Fwd: 779 Warren Avenue

Subject: RE: [779 Warren Avenue](#)

Good afternoon, I am reviewing the proposed generator project and have the following questions:

Drawing file: 1. Original Plans / Metal Base Pad Dimensions.pdf

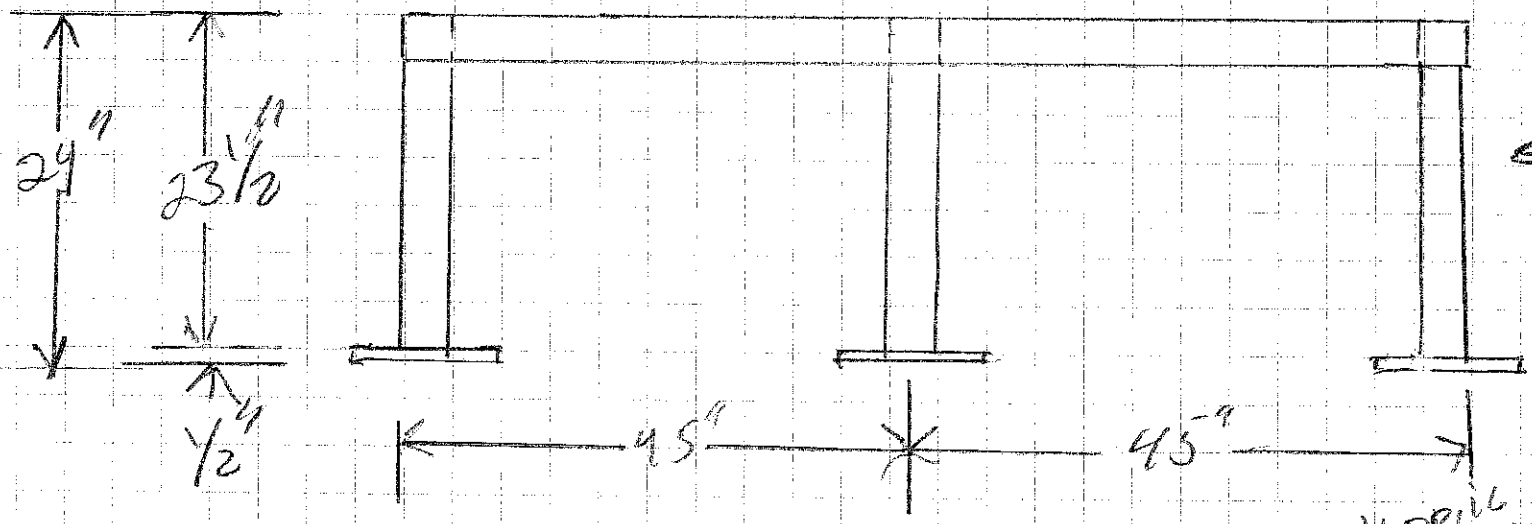
1. Is the pad reinforced?
2. Does the pad sit on a frost wall?
3. How thick is the pad?
4. Does the generator weight require a minimum concrete strength?

Thanks, sorry I didn't get my name on that one. This is also in flood plain so elevation and anchoring is critical.

1. Is the pad reinforced? **Yes, the Pad is precast 4ft. by 4ft. by 8inch. MFG by Swans.**
2. Does the pad sit on a frost wall? **No, it sits on 8 Plus inch of crashed gravel**
3. How thick is the pad? **4 inch per Kohler**
4. Does the generator weight require a minimum concrete strength? **No, whereas the generator is mounted on a steel frame raising the unit approximately 30 inches above grade Generator weighs 1,960 lbs.**
